14th November 2013

Council Office Extension Ref: N6/2013/1938/MA

Title Proposed Materials

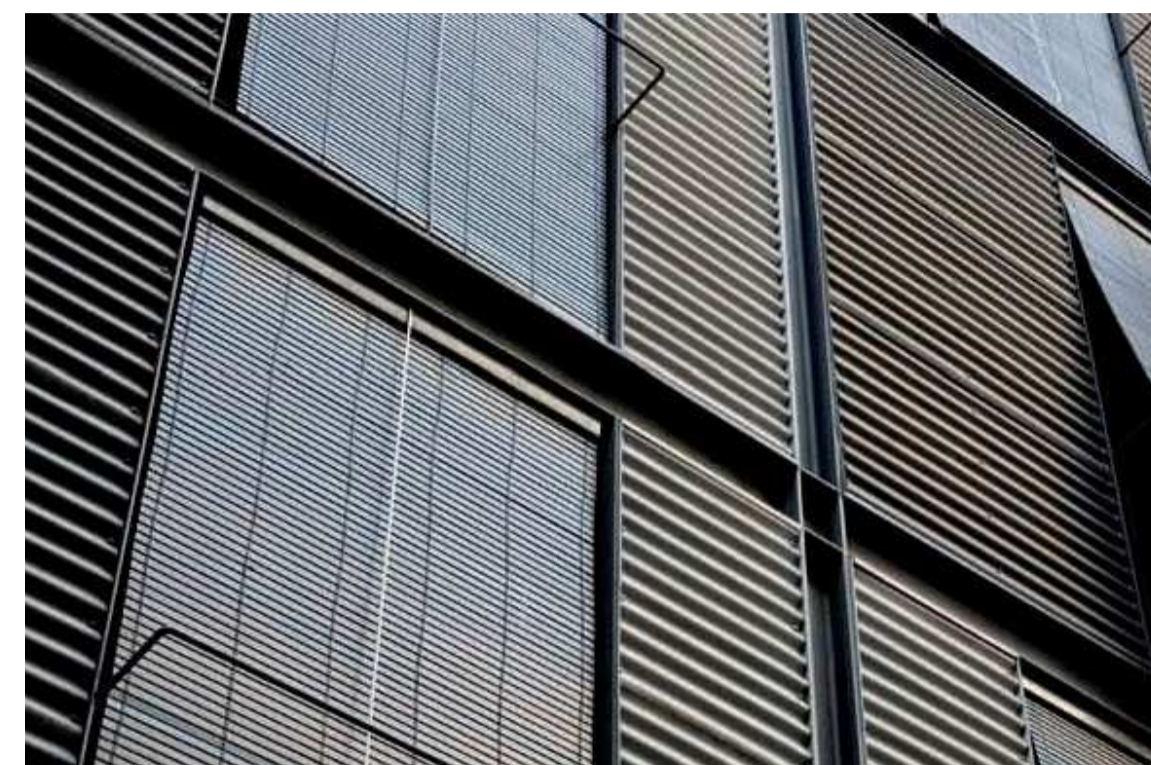
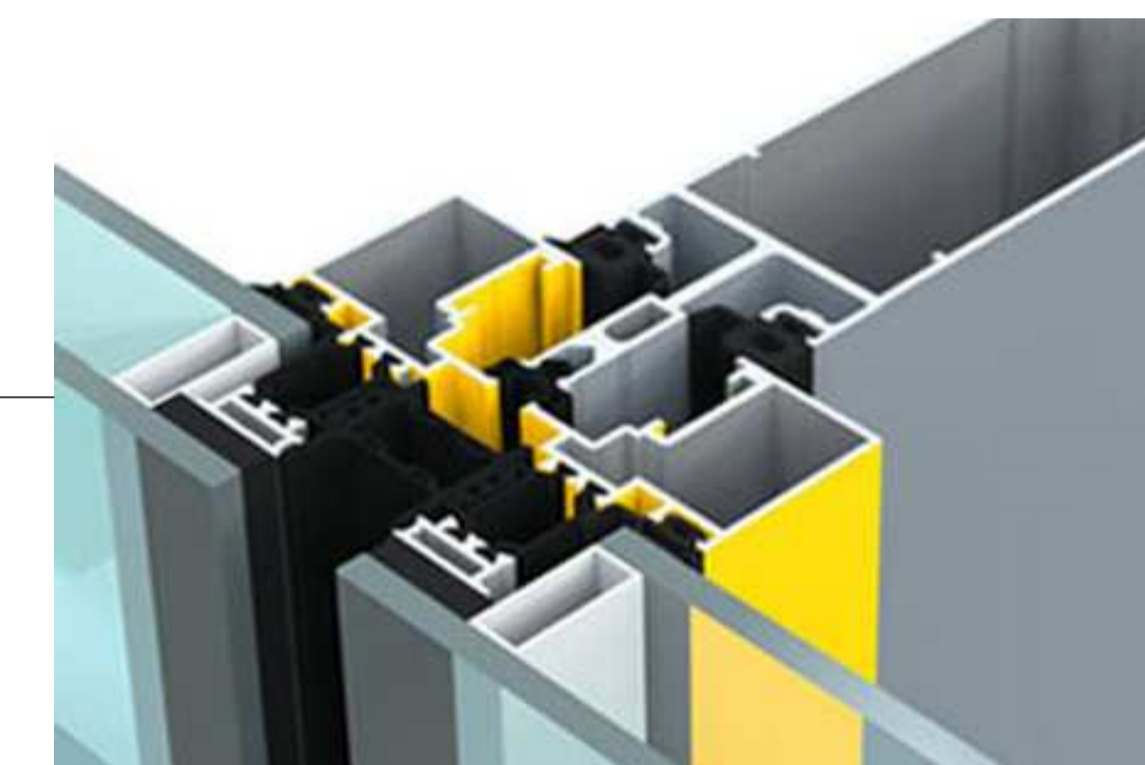
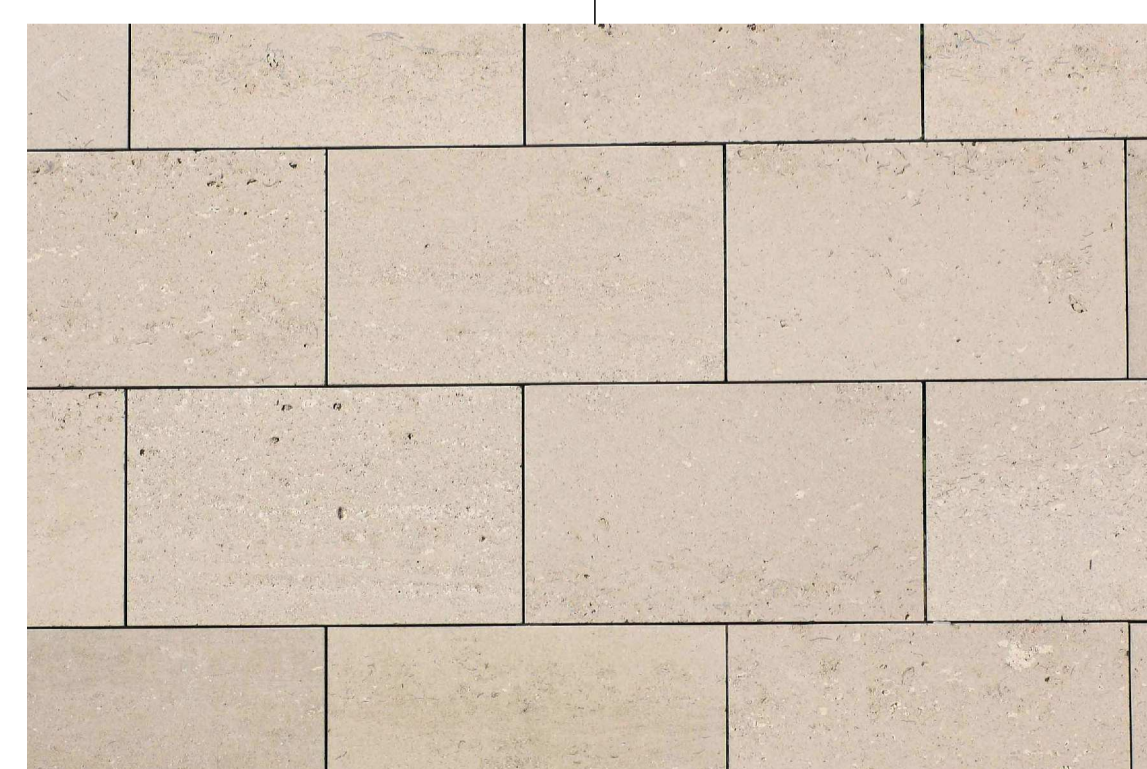
- 2) The angular glass structure is ugly, out of scale and detracts from Cecil Elsom's award winning building. It does not 'respect the materials and setting' nor is it 'subservient to the existing building' which are conditions that the Council impose on all other residents and businesses. The Council should be leading by example, not flouting its own planning rules.

The large glass entrance is still completely out of character with the existing building and those buildings forming the central core of the town, for which Welwyn Garden City is highly regarded. This is an award winning iconic building in the centre of the town so I should like you to explain on what basis you can justify something which is so out of keeping. The Council still does not appear to have learnt any lessons from their past mistakes and this seems to be heading for yet another ill-conceived disaster.

Planning rules exist to prevent inappropriate development and the preservation of the Conservation area in Welwyn Garden City is dependent on them being rigorously applied. The current plans still fail to satisfy the requirement that all development in the Conservation area must be appropriate in terms of design and materials and should be subservient to the existing building.
